Mr Brad Campbell
Bursar
THE TRUSTEES OF THE SYDNEY GRAMMAR SCHOOL
SYDNEY GRAMMAR SCHOOL
10-12 COLLEGE STREET
DARLINGHURST 2010
19/05/2021

Weigall Sports Complex, Sydney Grammar School (SSD-10421)
Request for additional information

Drawing No.
A4103

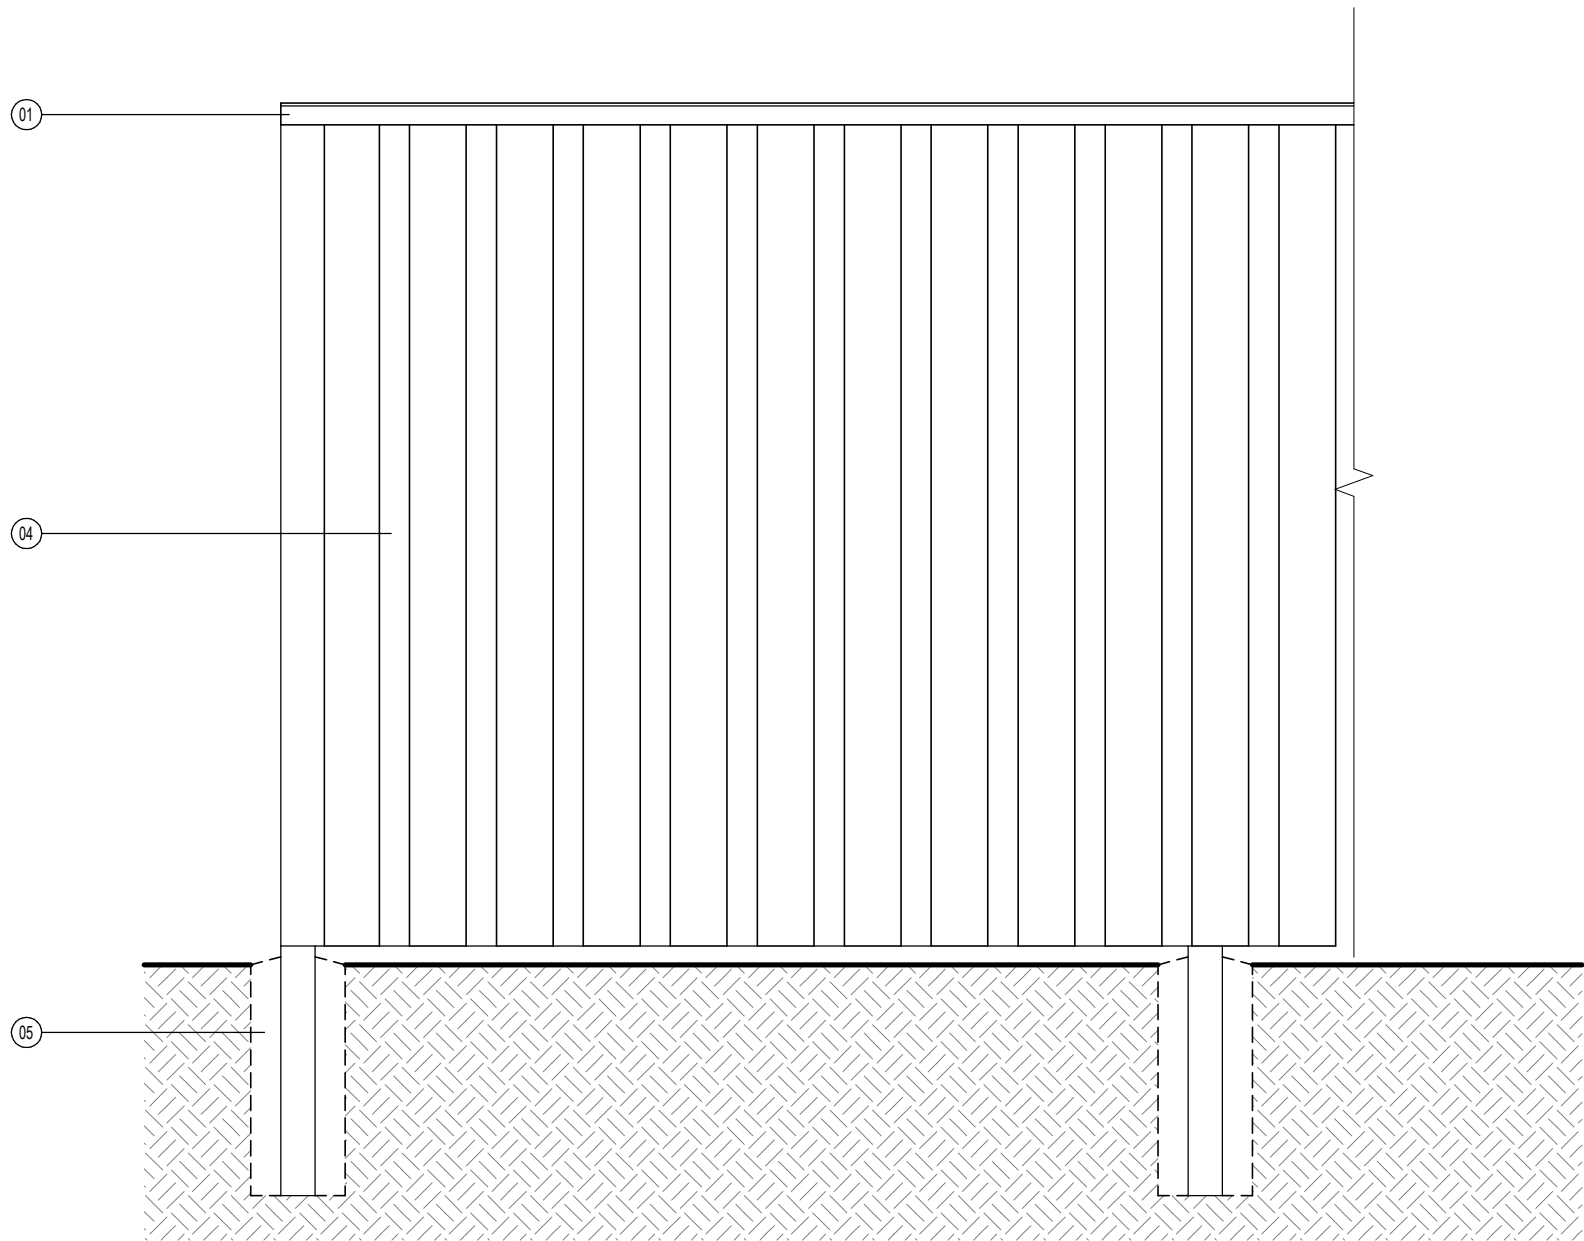
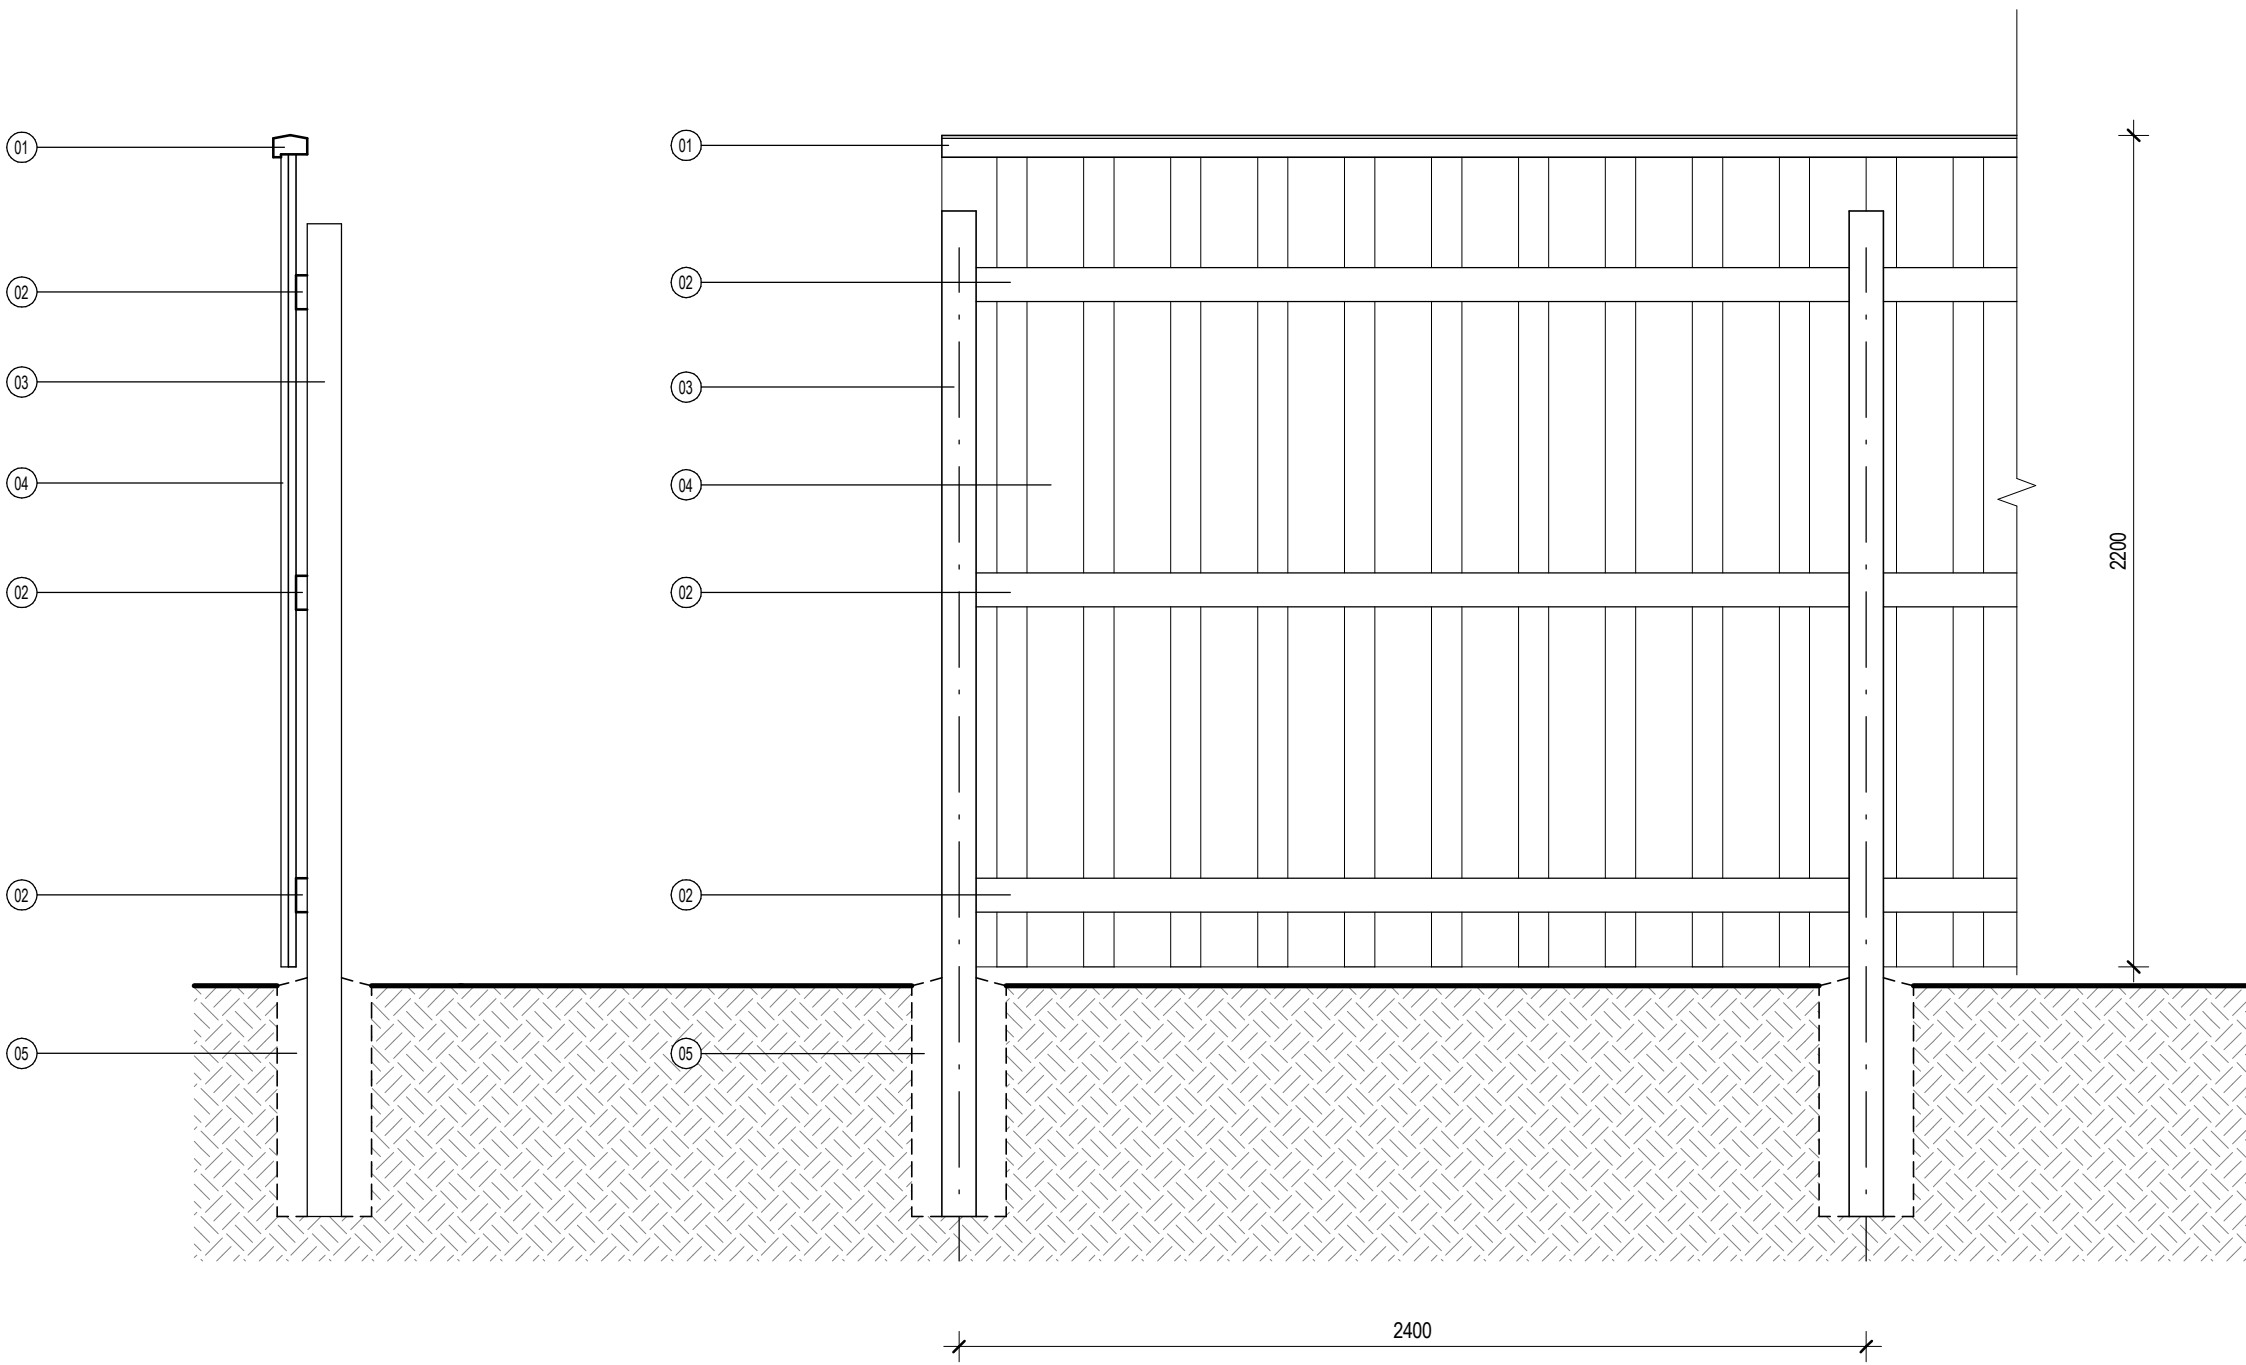
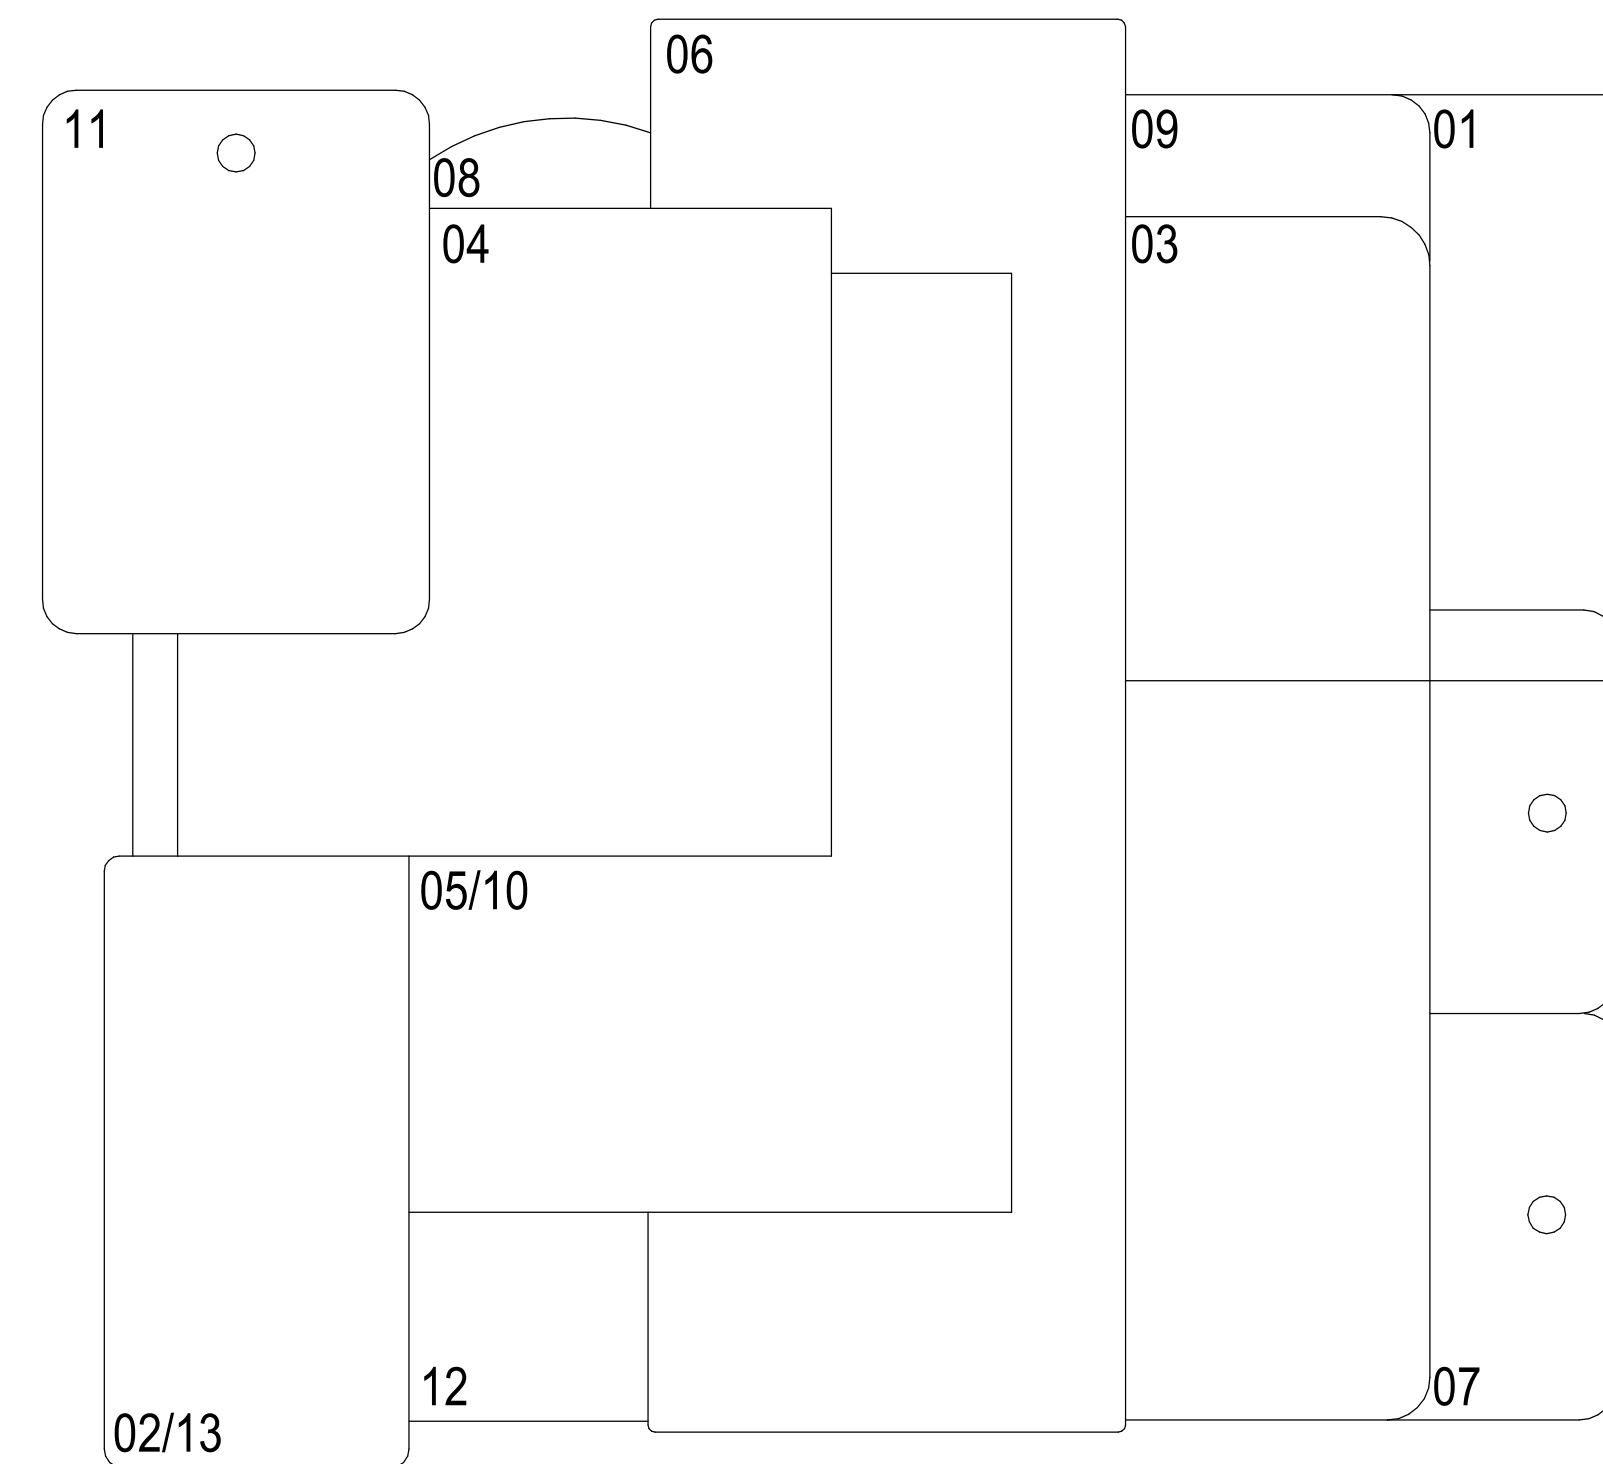
- a) The submitted drawing A4103 shows the acoustic fence as 1.83m tall (not 2.2m tall as confirmed in the EIS and drawing A2101). Confirm the acoustic fence height and update all the relevant plans. In addition, provide a date on drawing A4103.
- b) The submitted drawing A3100 should be updated to clearly indicate which windows are to comprise obscure glazing.
